# Engineering Comment Responses

Project: Nguyen Residence  
Subject: 2<sup>ND</sup> Review Engineering Comments Permit #2204-199

1 PERMEABLE CONCRETE SIDEWALK SECTION

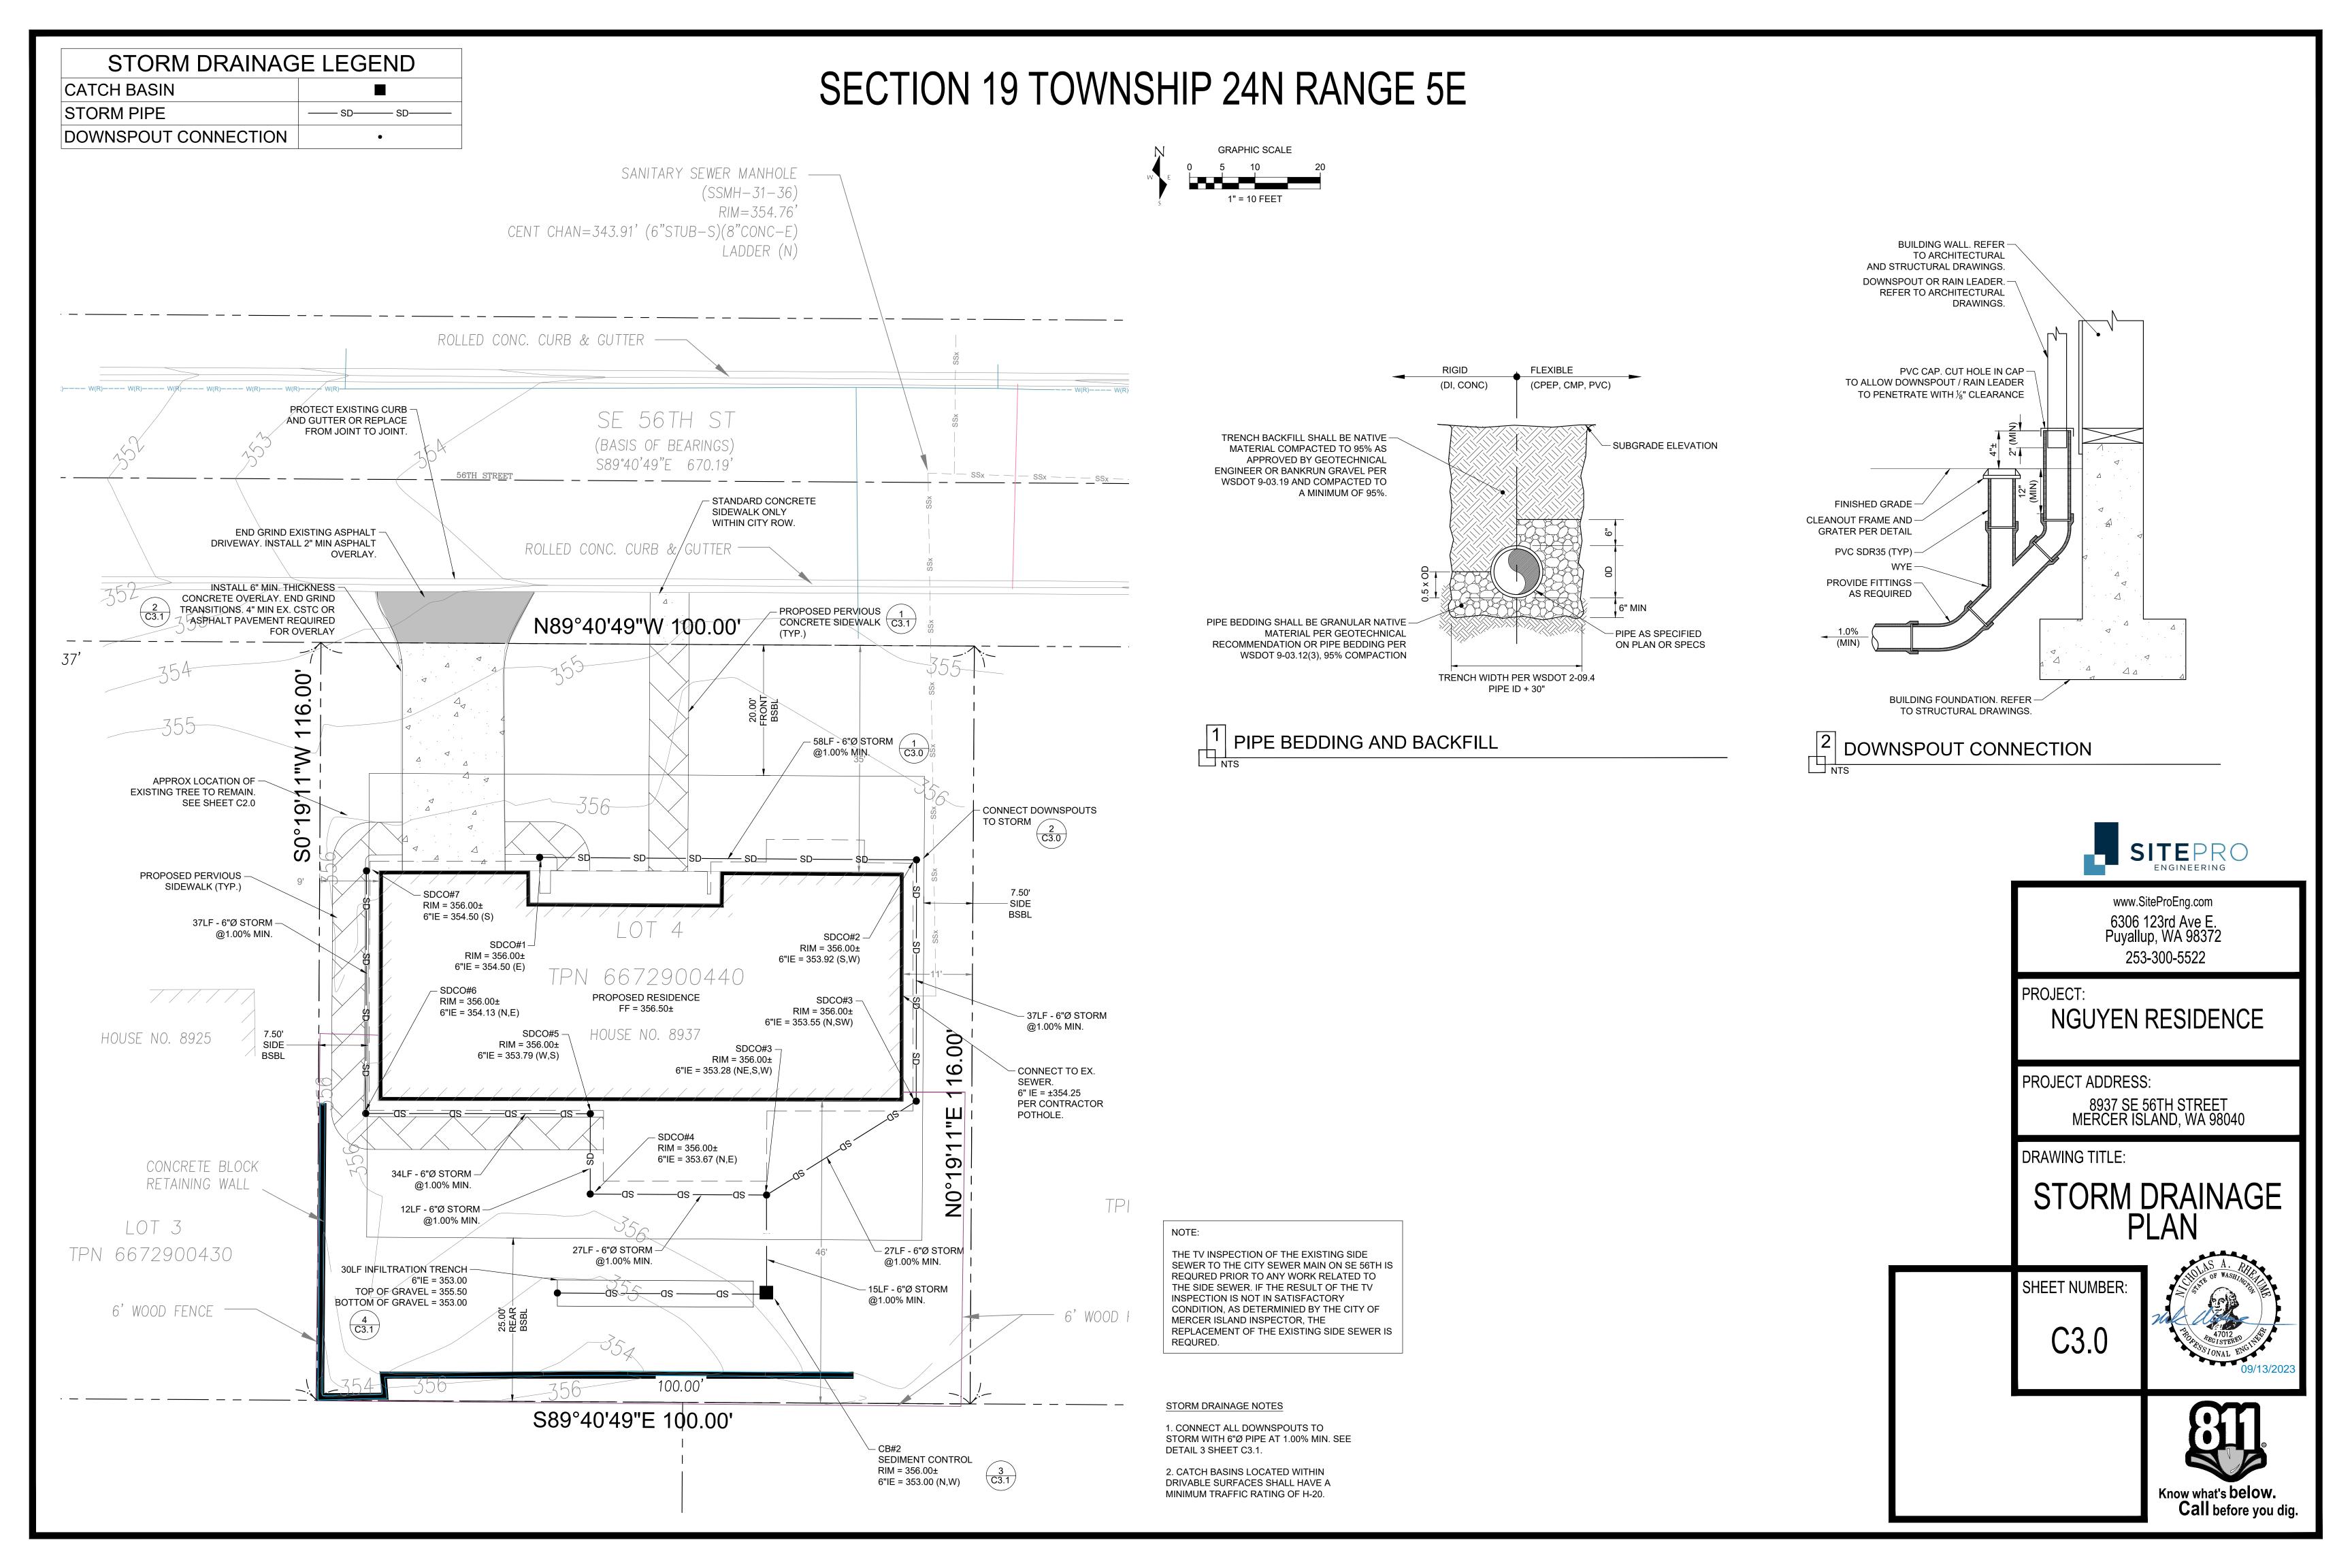
4. Provide more design and details for the pervious sidewalks such as the pervious surface type (concrete, asphalt, pavers, grid system), details for the material layers/types/thicknesses/etc. See report comment regarding evaluation for feasibility of pervious pavement. **Pervious pavement details added as requested, report comments addressed.**
